Rezoning Transportation Analysis

Petition Number: #2022-096

From: Jake Carpenter, PE
Jacob.Carpenter@charlottenc.gov
980-221-5675

General Review Information

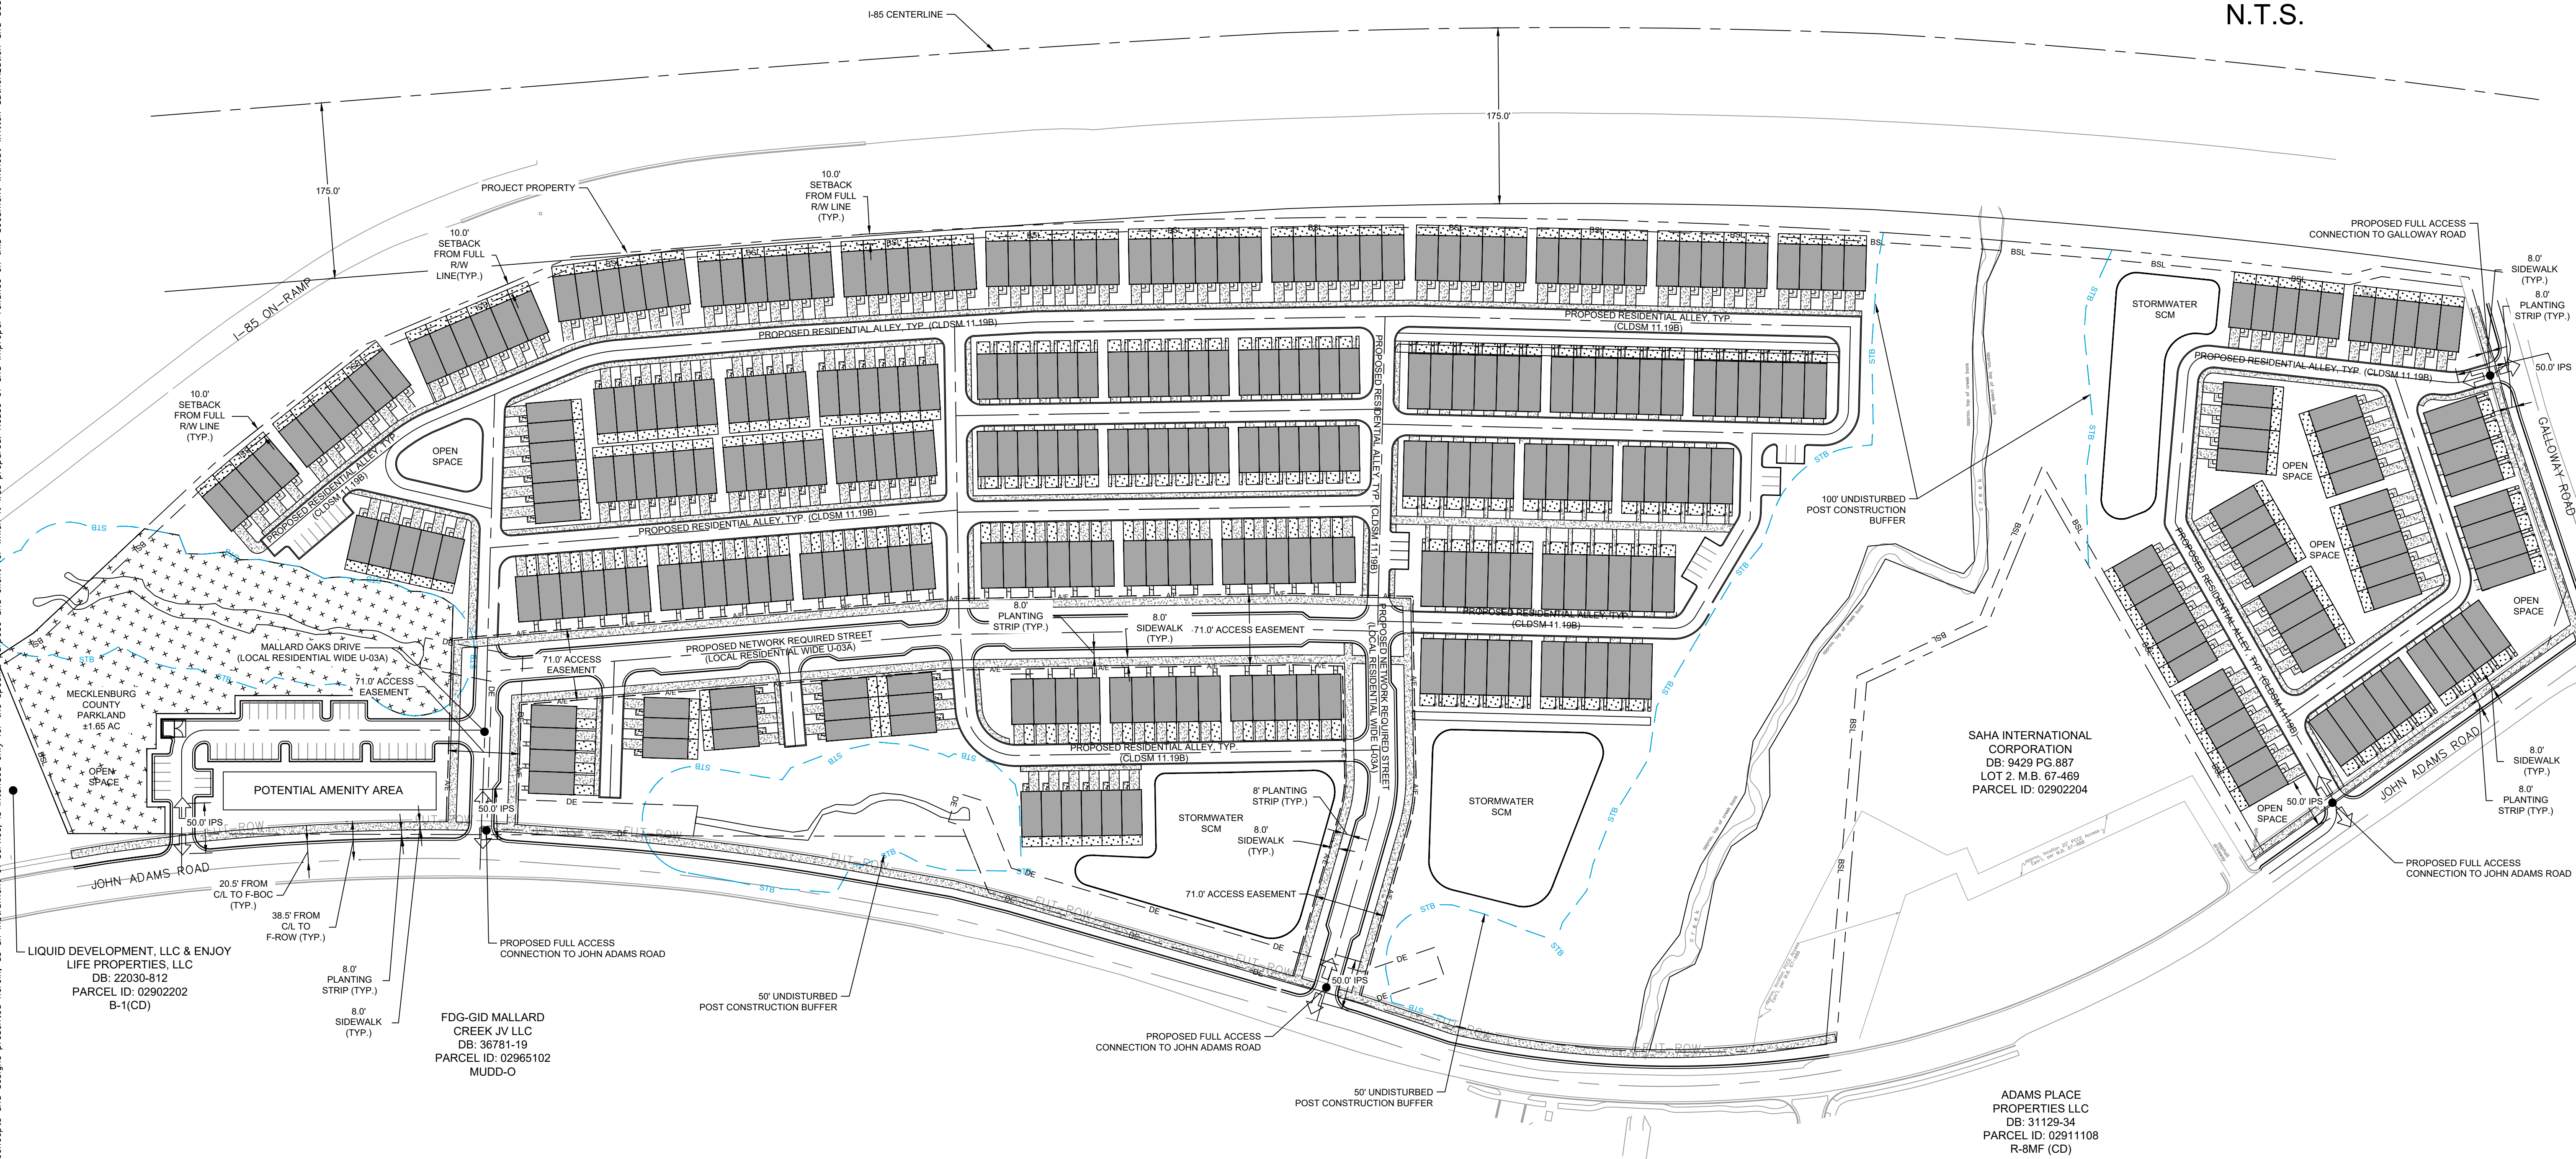
11. **New Comment 6.21.2023:** Label and dimension internal channelization (internal protected stem) and ensure that each driveway provides a minimum 50 feet. No parking shall be allowed within the minimum 50 feet of internal channelization.

3. ~~New Comment 07.28.2023:~~ Due to the increase in unit count and trip generation for the site along with additional development in the direct vicinity of the site, CDOT is **REQUESTING** that the development complete a Comprehensive Transportation Review (CTR) as outlined in Article 32.1 of the UDO and the Charlotte Streets Manual.
4. ~~Revise site plan and conditional note(s) to commit to dedicate 38.5 feet of right-of-way from the road centerline. The site plan shall label and dimension the right-of-way from the road centerline.~~
5. ~~Revise site plan and conditional note(s) to commit to construct an 8-foot planting strip, and 8-foot sidewalk on John Adams Road and Galloway Road per Chapter 19. The site plan shall label and dimension both items from the back of curb and gutter and road centerline.~~

~~Clarifying comment 6.21.2023: Label and dimension 8-foot planting strip and 8-foot sidewalk on John Adams Road.~~

6. ~~The proposed dwelling units exceeds 12 per acre. Per Chapter 20 Subdivision ordinance, site plan and conditional note(s) revisions are needed to commit to construct an 8-foot planting strip, and 8-foot sidewalk along John Adams Road, Galloway Road and all internal network required public Streets. The wider sidewalk also meets the Charlotte WALKS Policy.~~

~~Reference (GLDSM standard detail U-05A and U-03A) for street typical.~~

~~Clarifying comment 6.21.2023: Label and dimension 8-foot planting strip and 8-foot sidewalk on all internal public streets.~~
